COUNTY COUNCIL'S RESPONSE TO CONSULTATION ON THE FOLLOWING DEVELOPMENT PROPOSAL

Application No: 18/00825/HYBRID-2

Location: Heyford Park Camp Road Upper Heyford

Response date: 8th June 2018

FIGURE 2

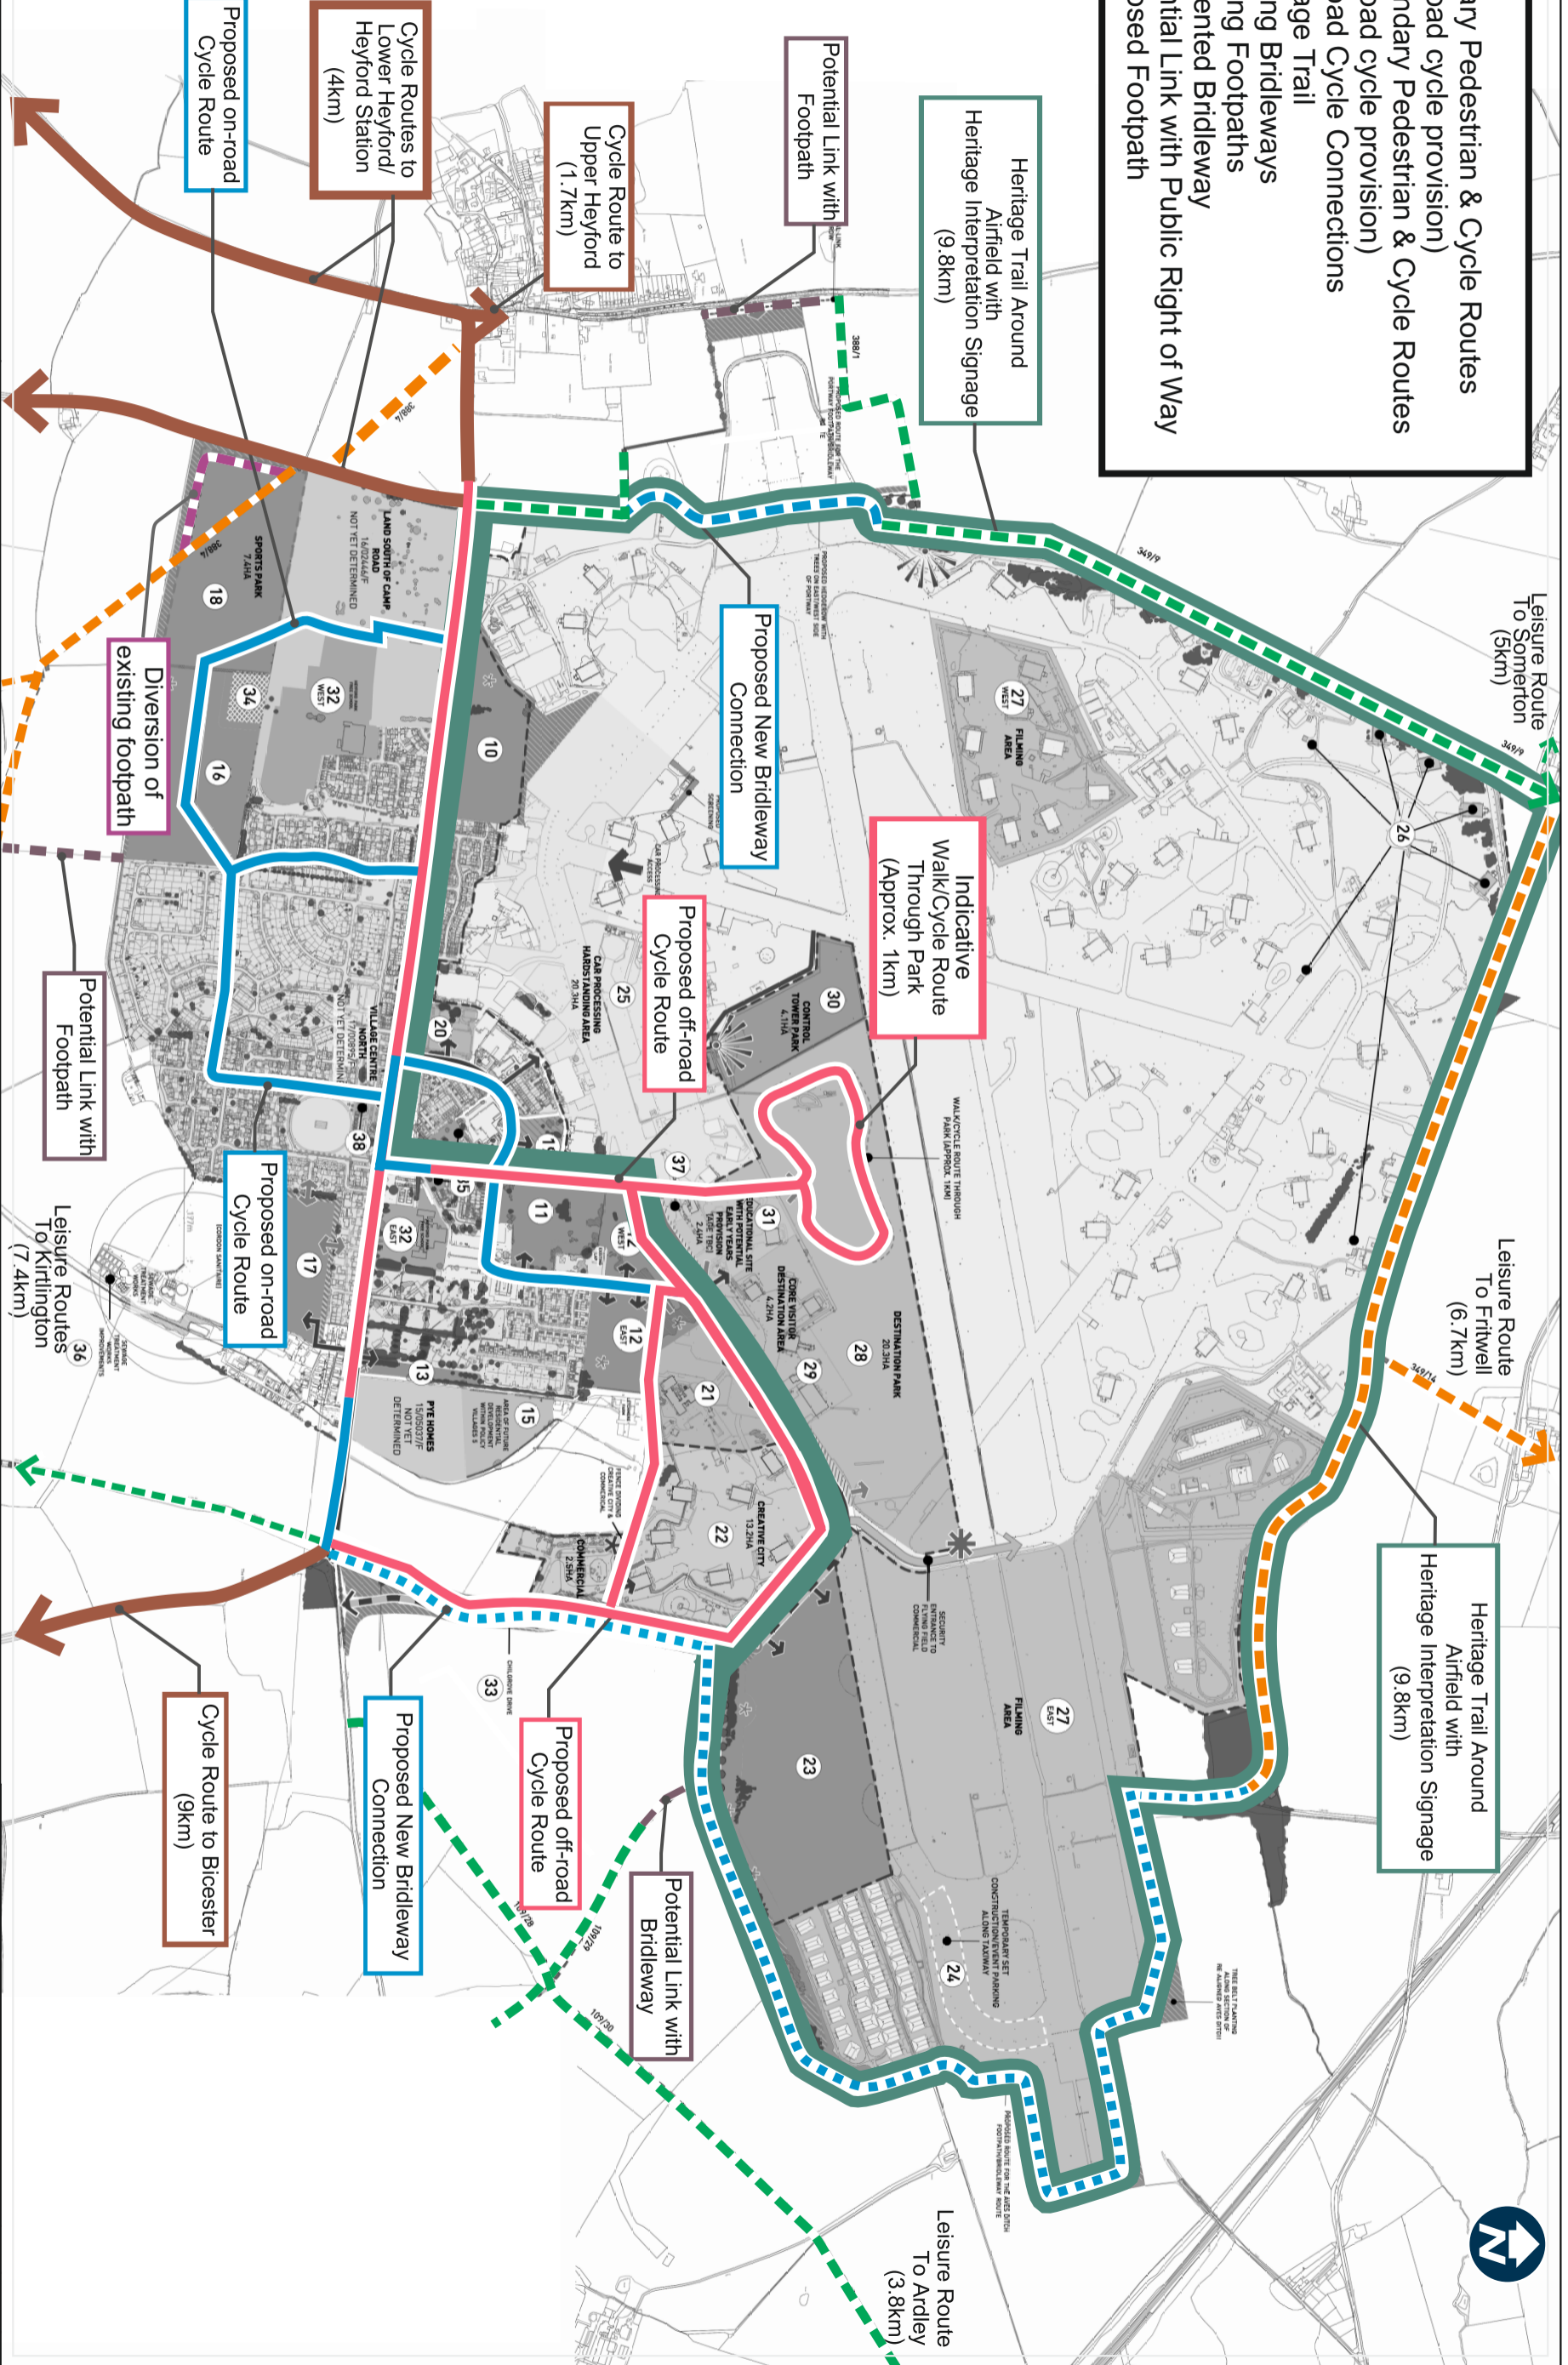
Section 3.2.1 states that *"A new pedestrian crossing is to be provided on Camp Road close to the school's pedestrian access. This is likely to be a zebra crossing..."* This is not included in the Walking and Cycling Strategy for Heyford Park as shown on Figure 5.1, Rev B. However, this crossing is to be provided for within the Section 106 Agreement for planning application No.16/02446/F for Phase 9 of the Heyford Park development. Specific details of the crossing proposal are still under development in consultation between the County and the applicant.

I note that Figure 5.1 Rev B shows off-site cycle routes coloured brown and makes no distinction between the route to Bicester and the routes to Upper and Lower Heyford. While cycle infrastructure is proposed to be provided to Bicester, I am not aware of any such proposals towards Lower Heyford and this needs to be clarified. If no cycle infrastructure is proposed towards Lower and Upper Heyford, this plan is misleading.

Further discussion is required on this plan because it has omitted a circular route around the south of the site and improved linkages to the sports park. We need to be confident that internal connectivity is maximised across the site.
